Our ref: DOC20/996275

Your ref: SSD-9679

Hills of Gold Wind Farm – Environmental Impact Statement Exhibition

Hills of Gold Wind Farm – Environmental Impact Statement

Matter: 34963.  
Date: 24 October 2022.  
Prepared for: CW, Prepared by: AM. Last edited by: amackegard  
Layout: 34963\_F5\_NativeVeg  
Project: P:\34900s\34963\Mapping\34963\_ArcGISPro\34963\_BDAR\34963\_HoG\_BDAR\_AM.aprx

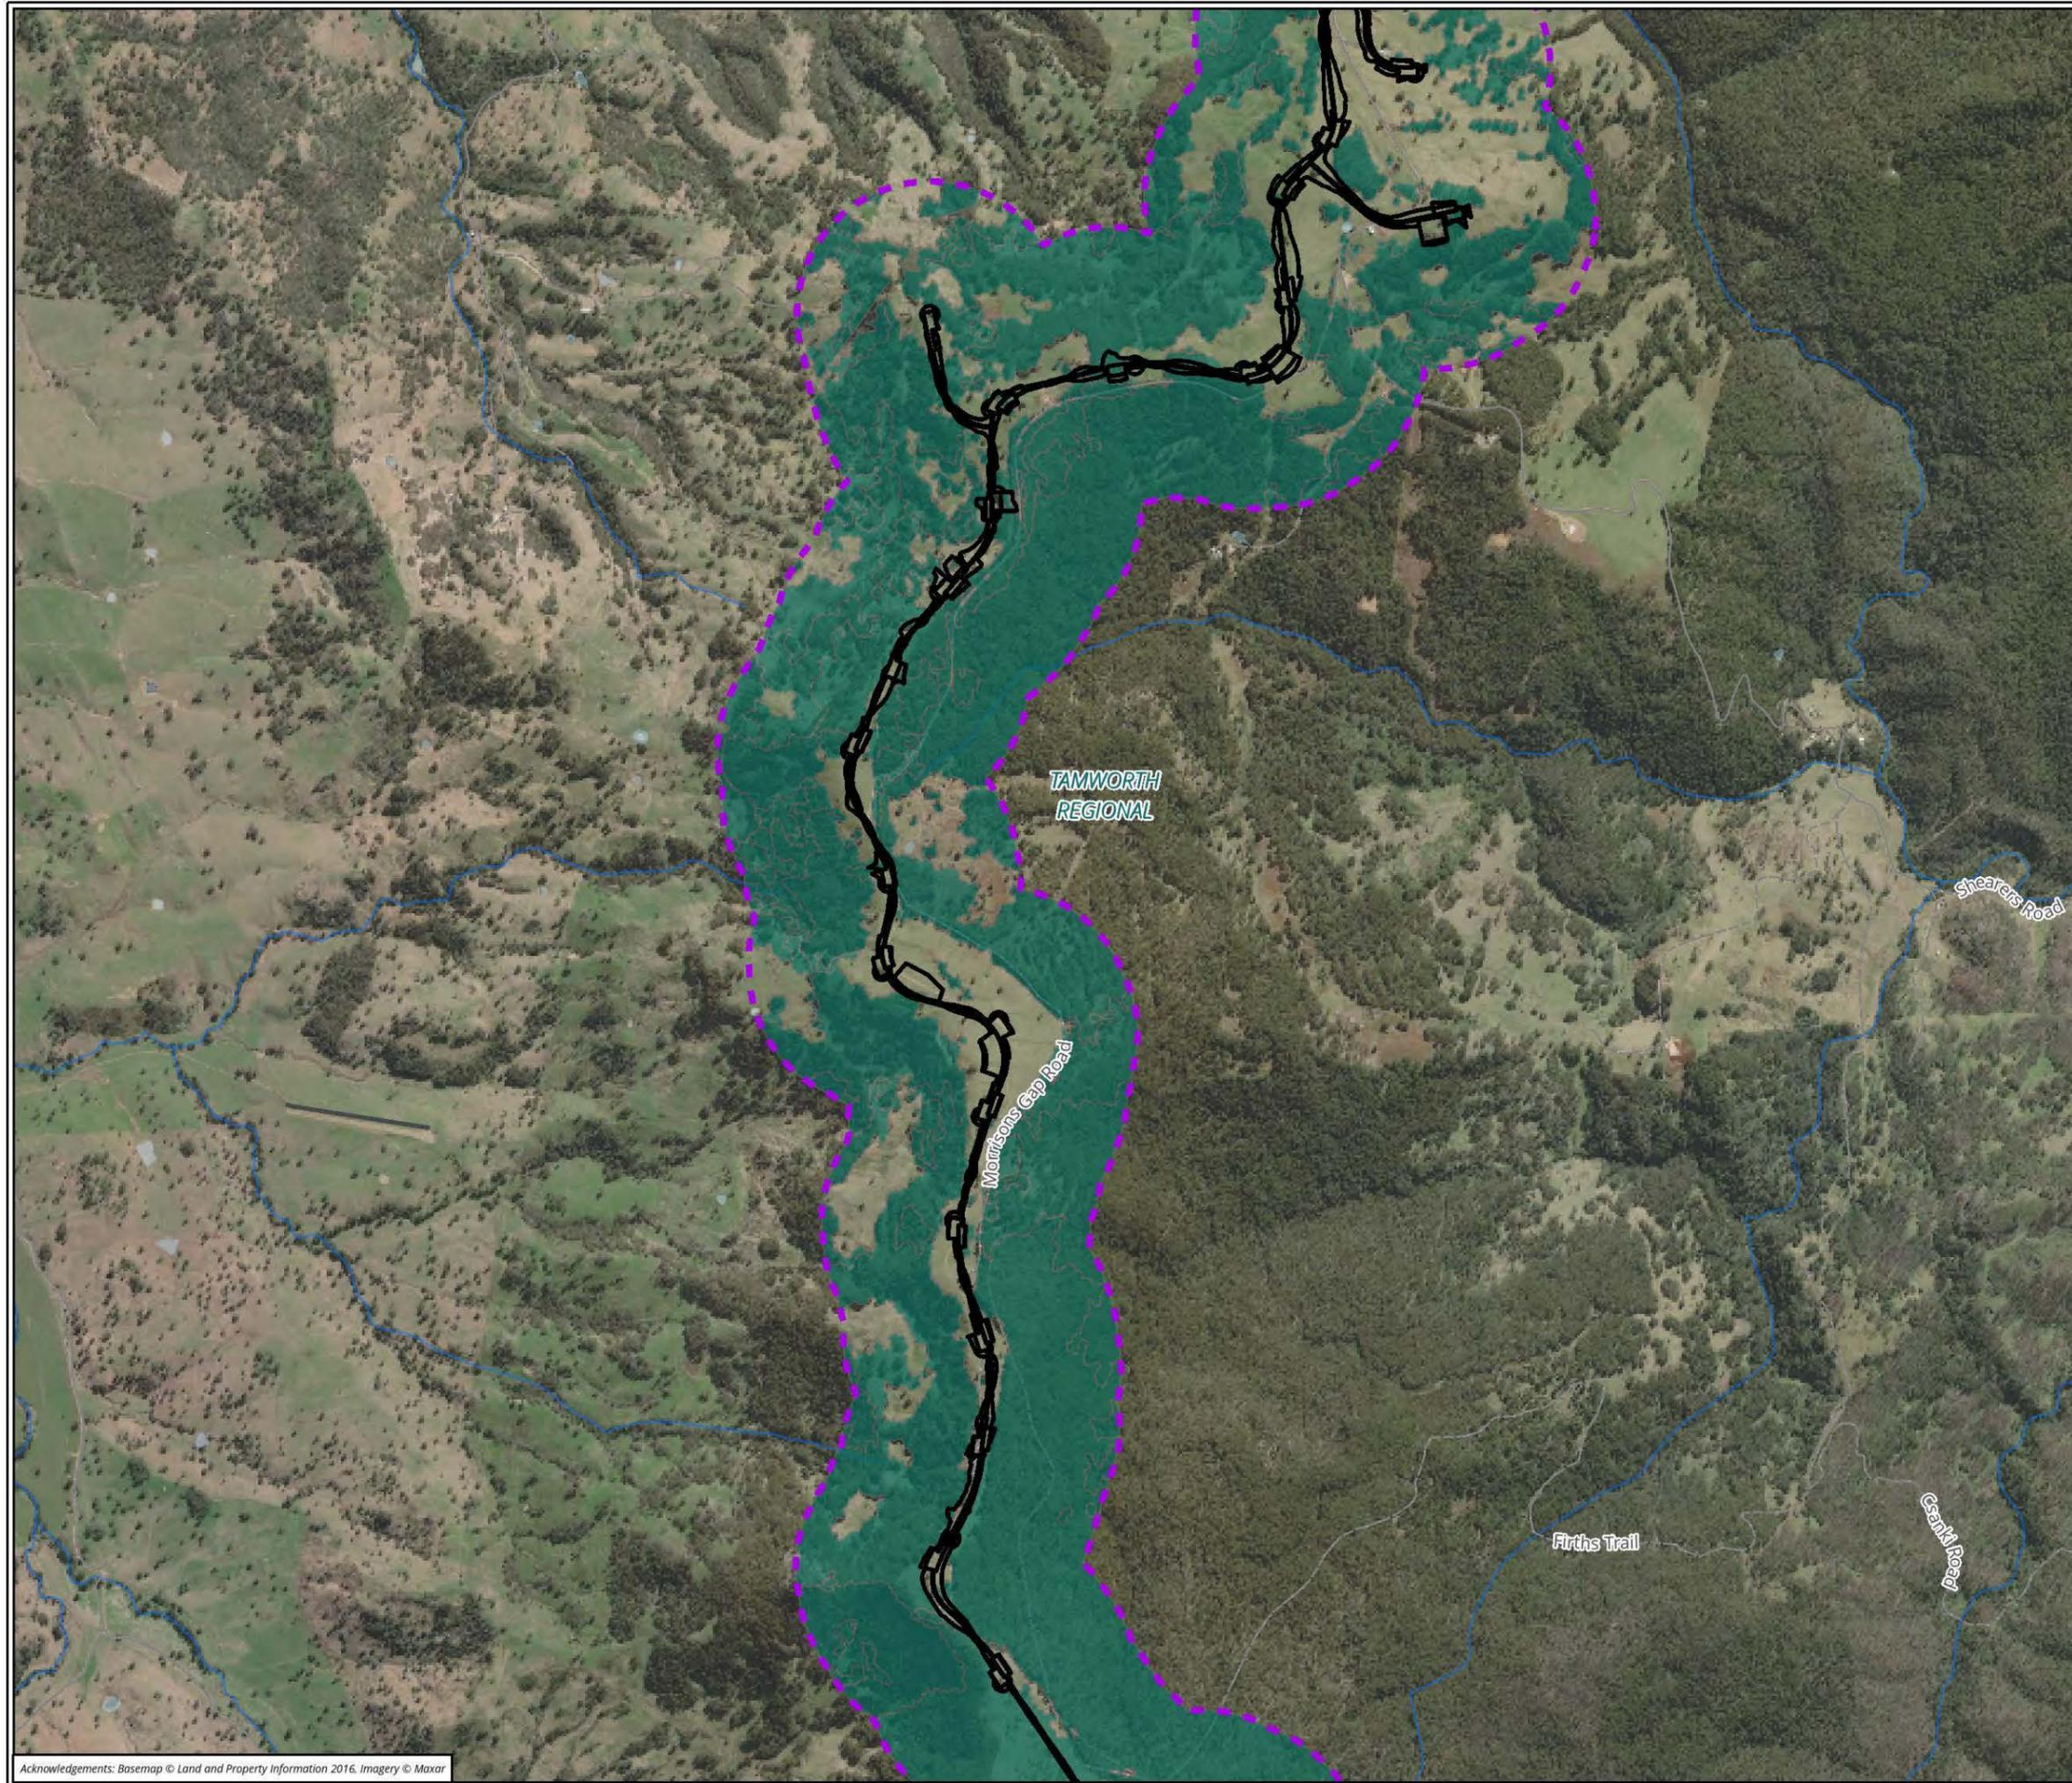
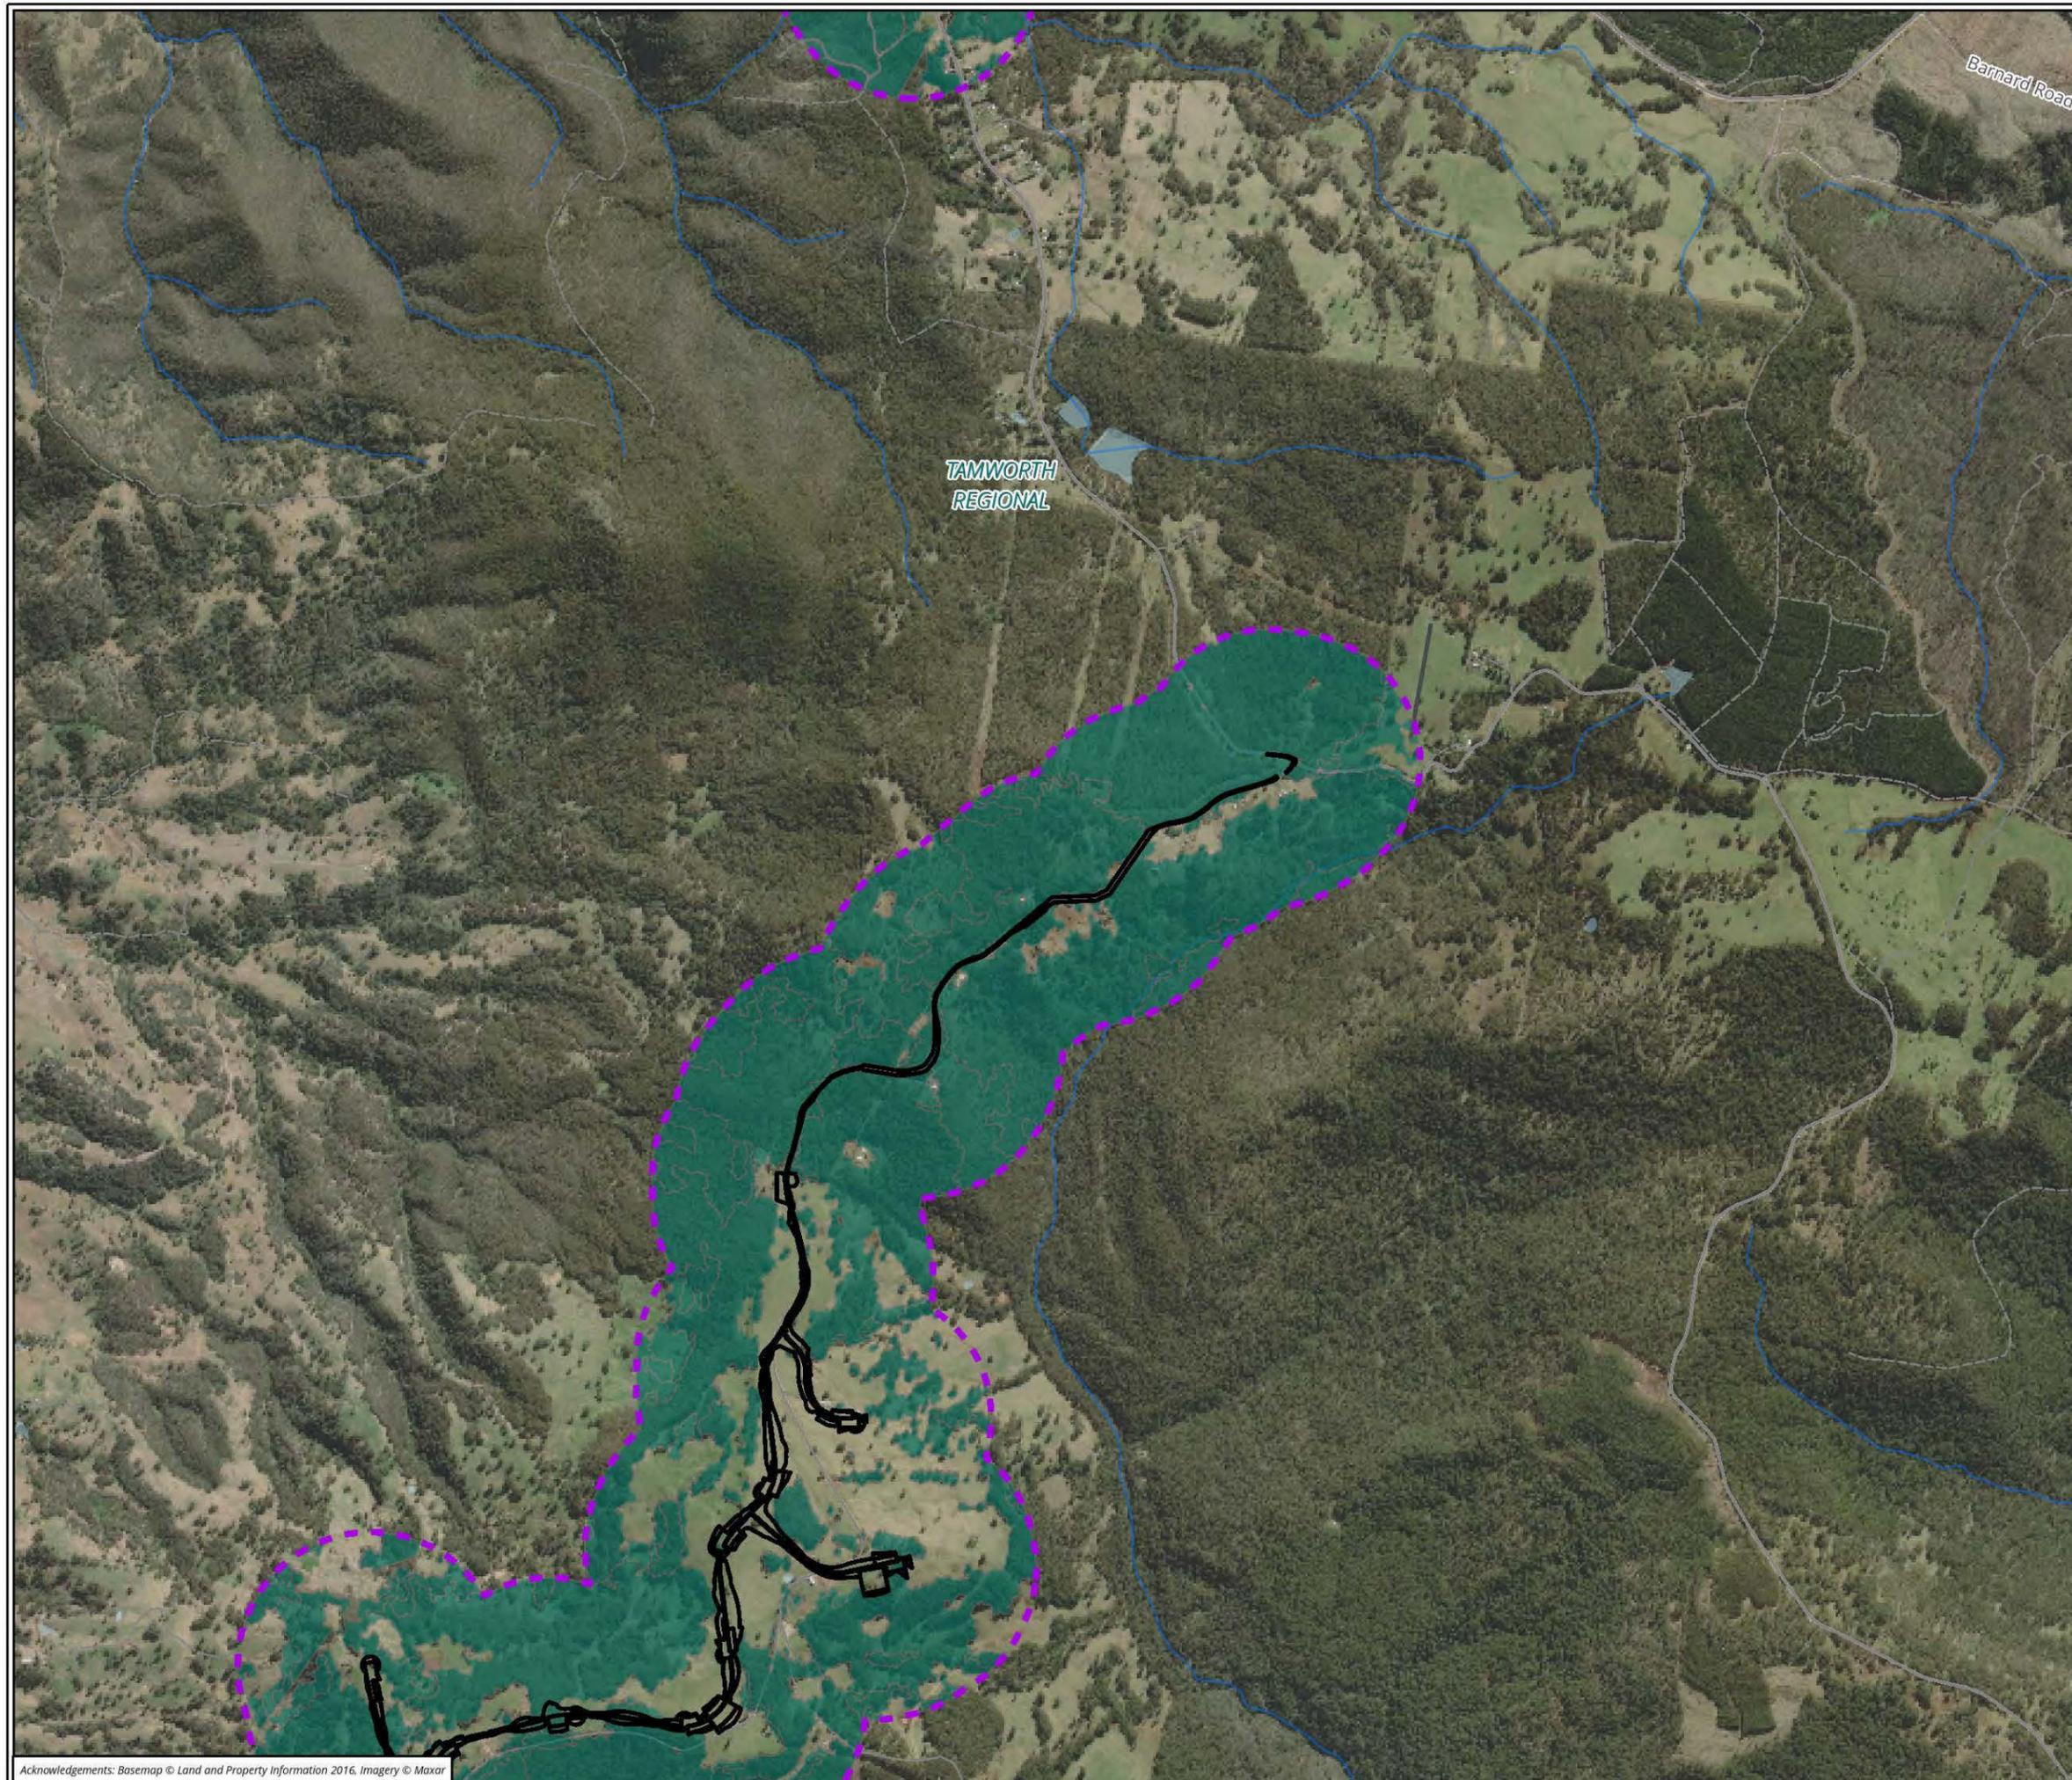
Appendix B of the BDAR provides detailed descriptions of the chosen PCTs. It is not clear whether the description, including species lists, is of the vegetation on site or a generic description of the PCT. Appendix B does not contain justification for the selection of these PCTs across the project site. While Table 11 of the BDAR provides the criteria used to assign vegetation condition classes, included exotic and planted vegetation, the BDAR provides no evidence to support these classifications that have been made and are displayed in Figure 5. Vegetation zones have not been mapped as required by the BAM.

The scale of some maps provided in the BDAR (Figure 5) makes it difficult to determine the location of the plot within the development footprint, however some plots (e.g. 1, 5, 8, 9, 21, 26) are clearly outside the footprint and therefore outside the related vegetation zones. The BAM requires plots to provide a representative assessment of the vegetation integrity of the vegetation zone. Plots must be appropriately placed within the vegetation zone and be geographically distributed throughout the project footprint. Where plots are not within the development footprint, the plot's inclusion must be justified. This should include providing evidence that the plot is in the correct PCT and that the plot data is consistent with other plot data collected in the vegetation zone. Where the inclusion of the plot cannot be adequately justified the use of benchmark data will be required.

- 3.1 Justification should be provided in the BDAR for the selection of all PCTs.
- 3.2 All vegetation zones must be clearly mapped.

- 4.1 Where vegetation plots are not located in the project footprint, justification must be provided, including evidence that the plot is in the correct PCT and vegetation zone, and that the plot data is consistent with other plot data collected in that vegetation zone.
